Judge Orr Eastonville Commercial Center

Traffic Impact Study

(LSC #194730)

July 10, 2020

BENNET RANCH SKETCH PLAN

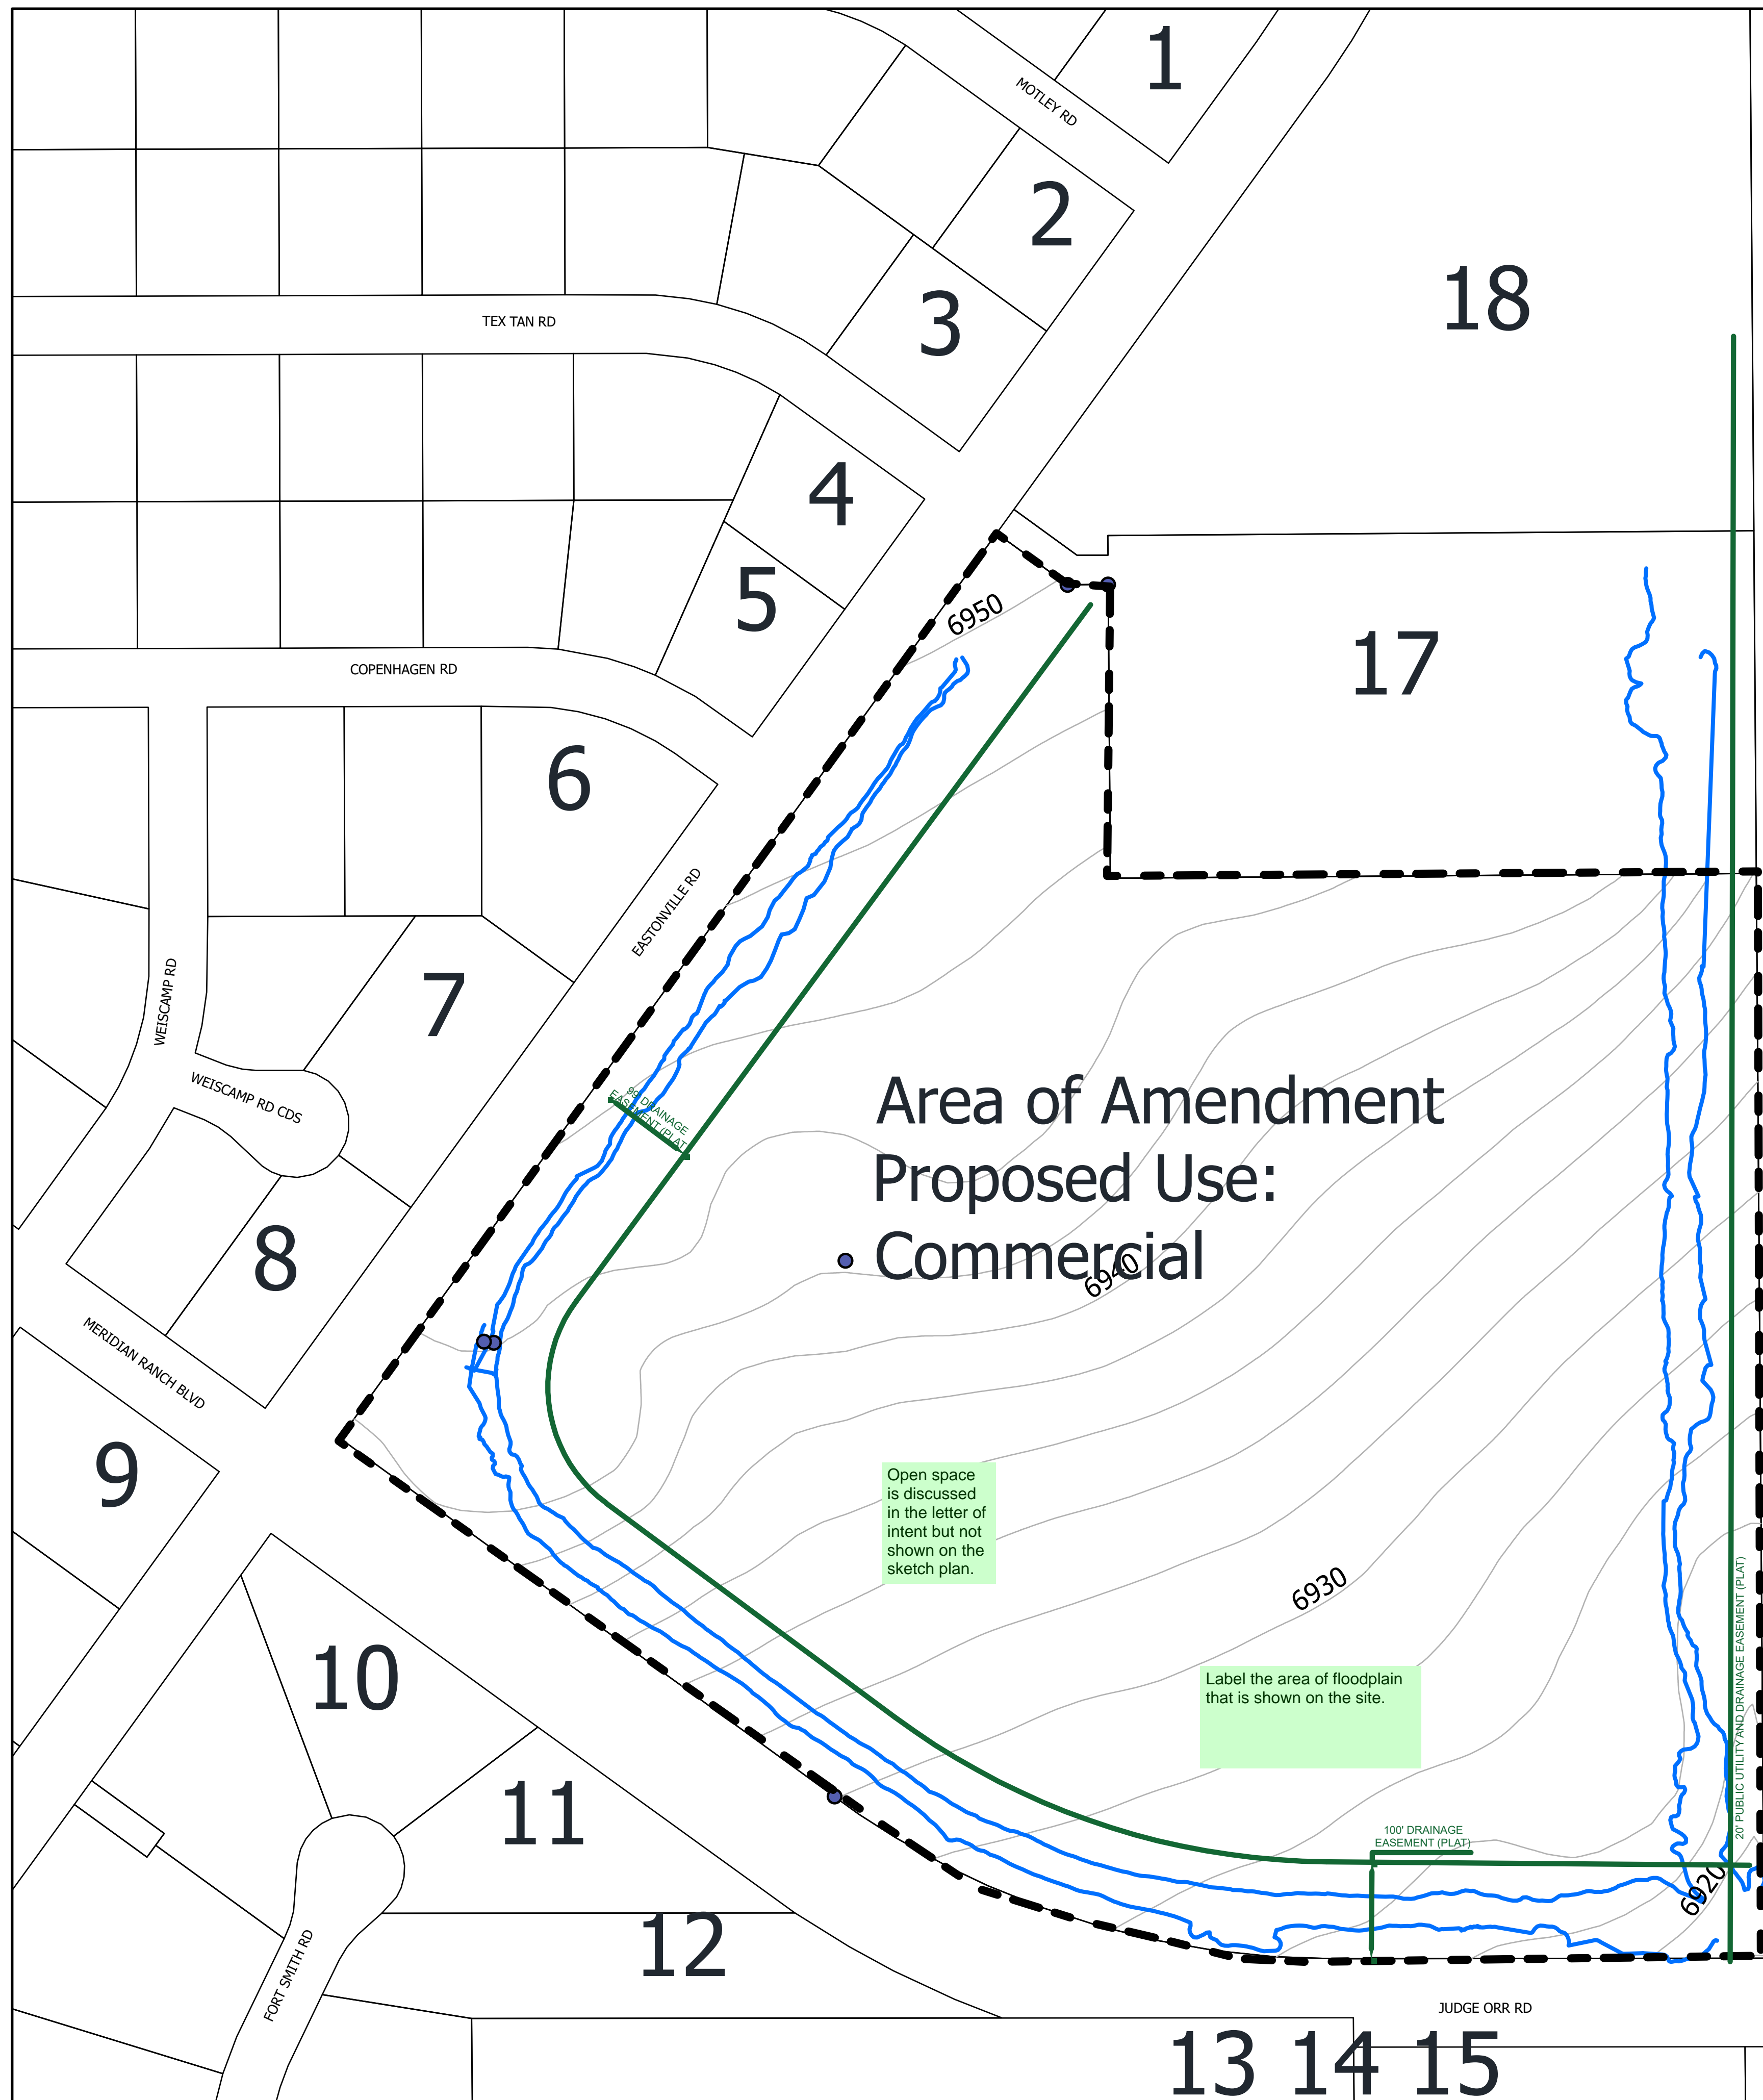
- "Meadowlake Ranch" – dated May 29, 2015
 - "Falcon Crossing" – dated February 5, 2007
- Please indicate the ECM criteria for intersection spacing and state whether these proposed roadways as currently shown in the conceptual site plan meet the criteria. If they do not, please indicate that deviation request would be needed.

The site plan on figure 2 indicates the distance as 1259 ft.

Please state something along the lines of: once the roadway locations are finalized at the preliminary plan/final plat a sight distance analysis with exhibit will be provided. If the proposed access locations shown on the site plan are final then provide sight distance analysis with an exhibit.

Please use County standard nomenclature for the anticipated classification of the internal roadways.
